EL PASO COUNTY GRADING AND EROSION CONTROL PLAN CHECKLIST

EPC Project Number: PPR2415

GRADING & EROSION CONTROL PLAN
EROSION CONTROL
C1.6 MVE PROJECT 61203
MVE DRAWING GEC-EC
MARCH 21, 2024
SHEET 6 OF 8

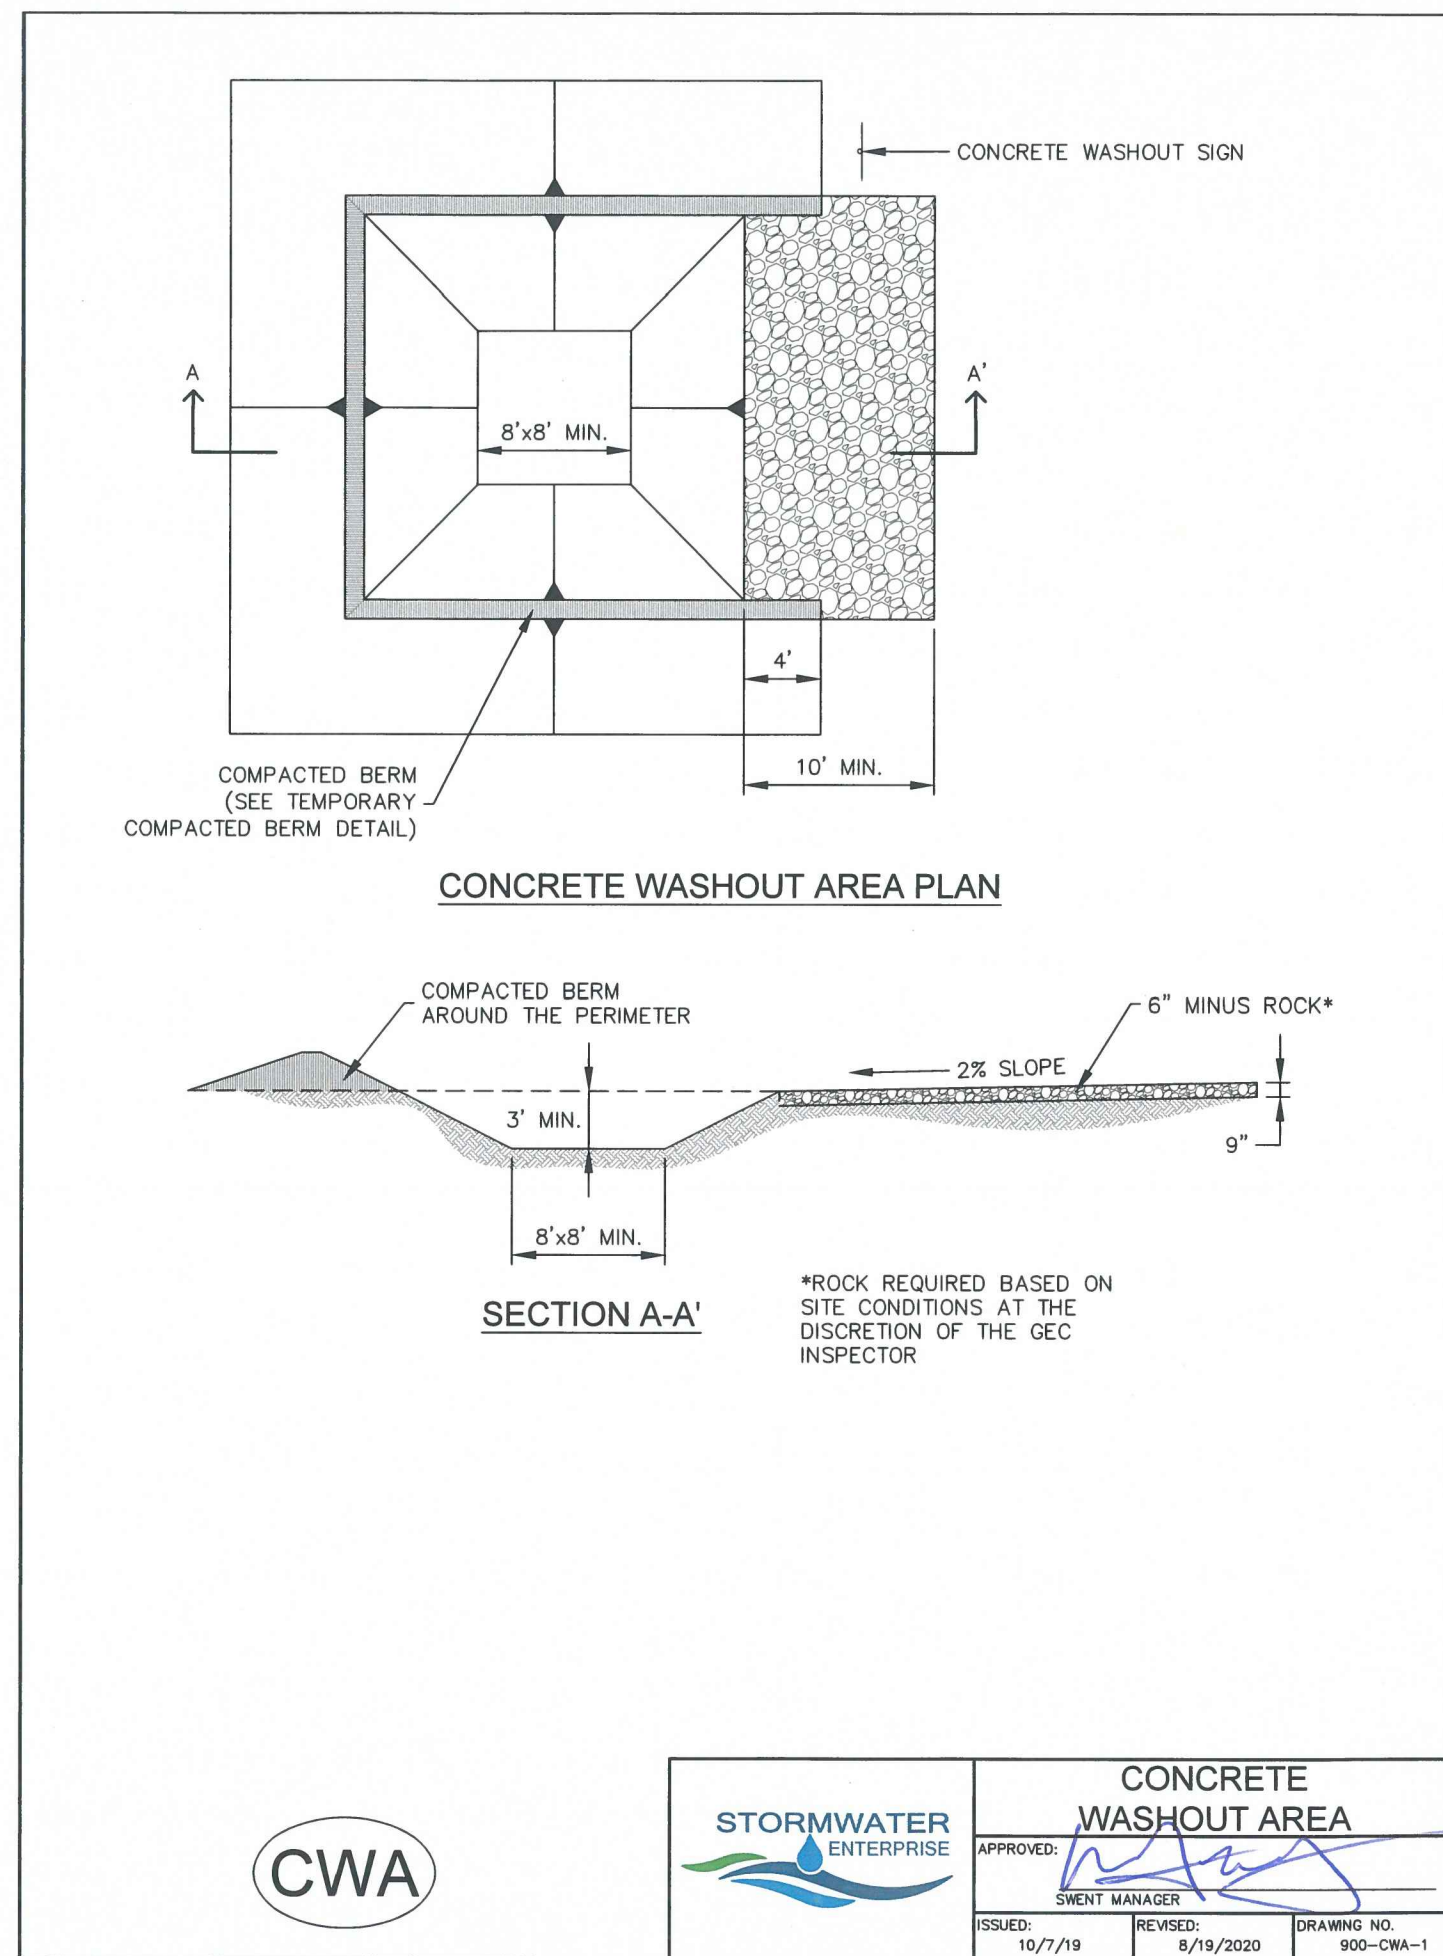
See my comment on Sht 6 of GEC Plans
